From: Simon Davis
Sent: 26 November 2019 17:32
To: [REDACTED]
Subject: FW: Y/101/19/DOC - Yapton View (land off Burndell Road), Yapton, BN18 0HW

From: Kate Giddings <kate.giddings@arun.gov.uk>
Sent: 26 November 2019 16:13
To: Simon Davis <Simon.Davis@arun.gov.uk>
Cc: Planning.Responses <Planning.Responses@arun.gov.uk>
Subject: Y/101/19/DOC - Yapton View (land off Burndell Road), Yapton, BN18 0HW

In relation to the above application, I understand from the submitted documents that Geo-Environmental's Remediation Strategy and Verification Report (ref.: GE18533/RSVR/SEP19, dated September 2019) has been provided with the aim of allowing discharge of condition 3 (remediation strategy) and condition 5 (verification plan). In order for this Department to consider discharging the conditions, please may the following points be addressed:

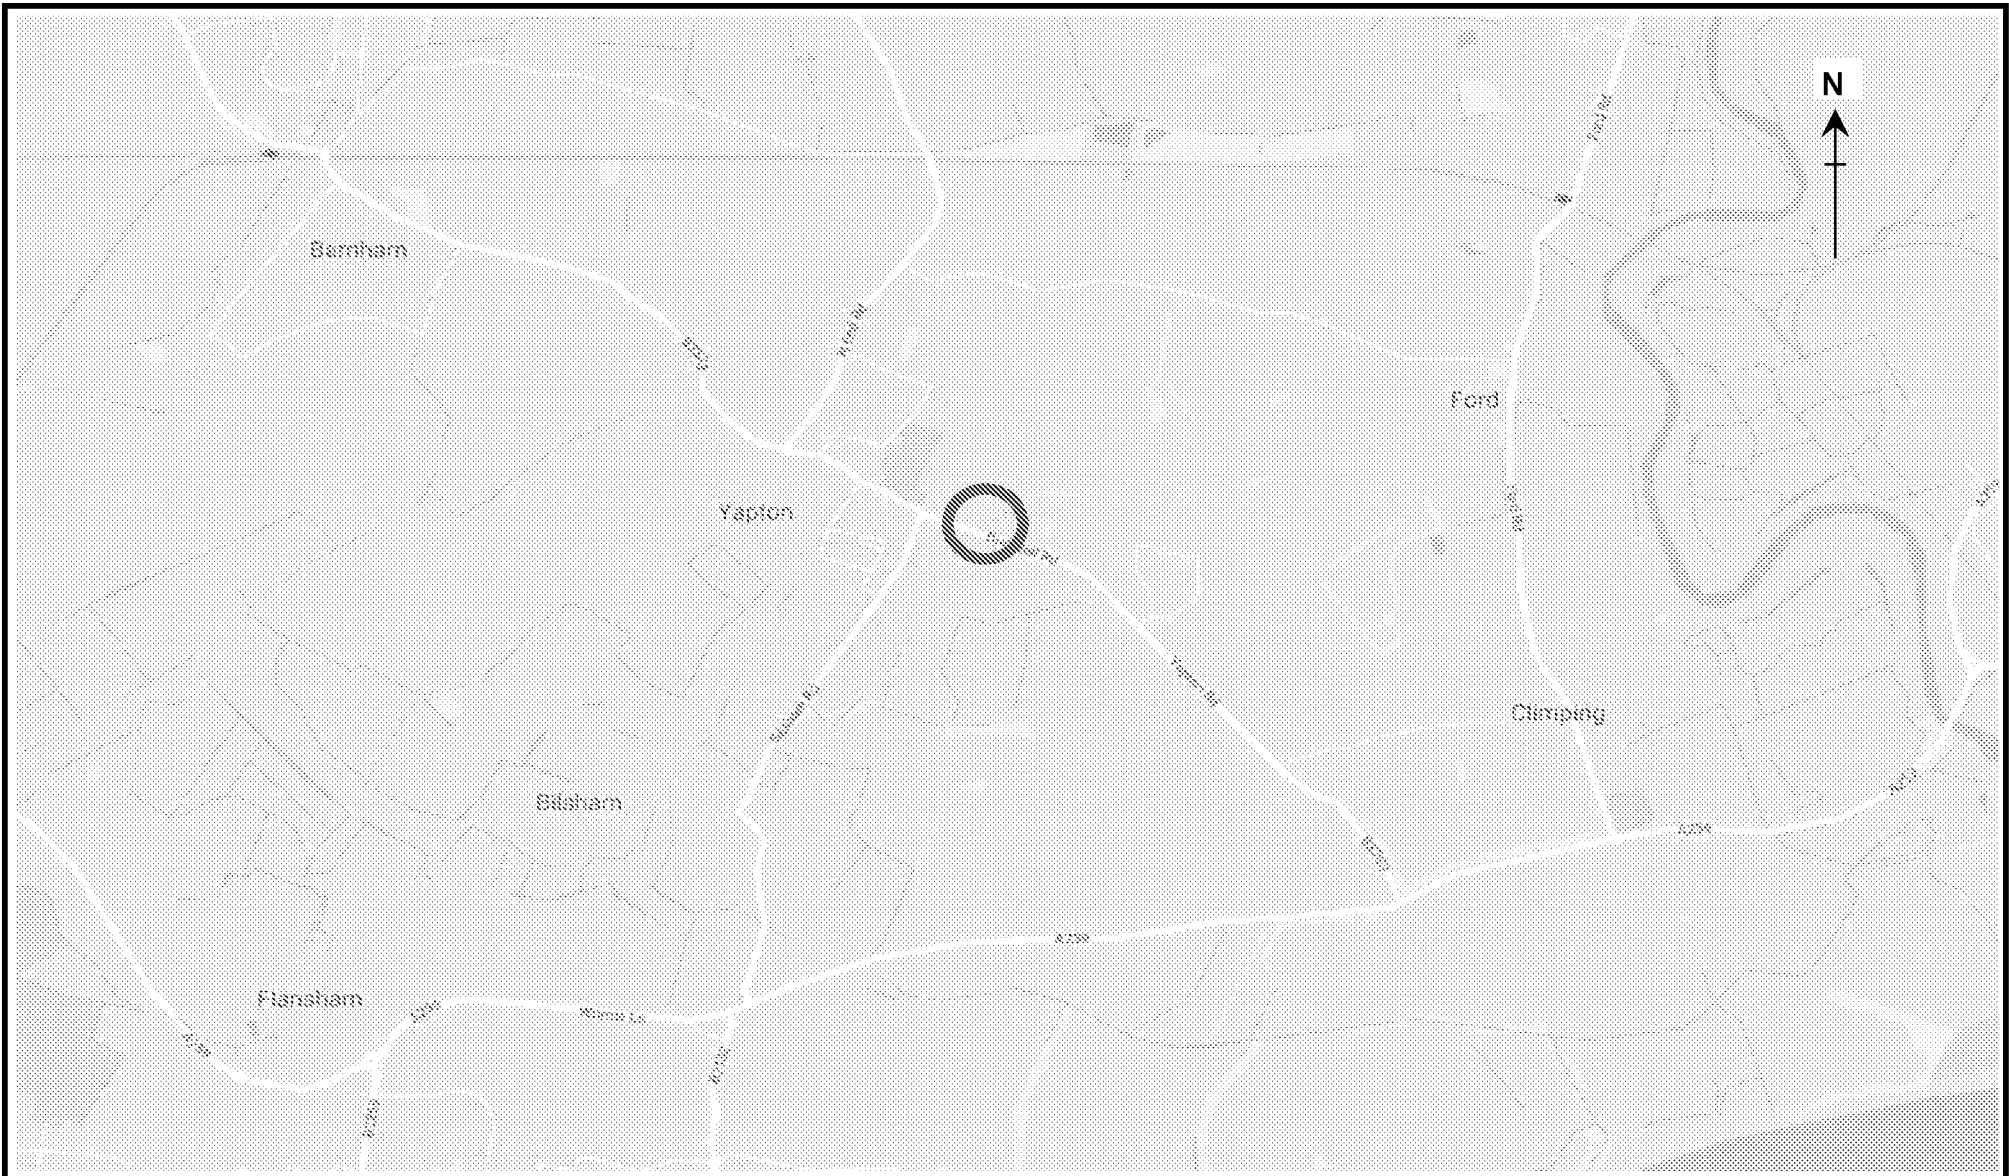
- date(s) of remedial work (it is noted that the visit to confirm the mass excavation was 15 April 2019)
- provision of the post-excavation validation sampling
- evidence of removal of material from site to a suitable facility (hazardous waste)
- evidence of the membrane placement
- evidence of material imported to site
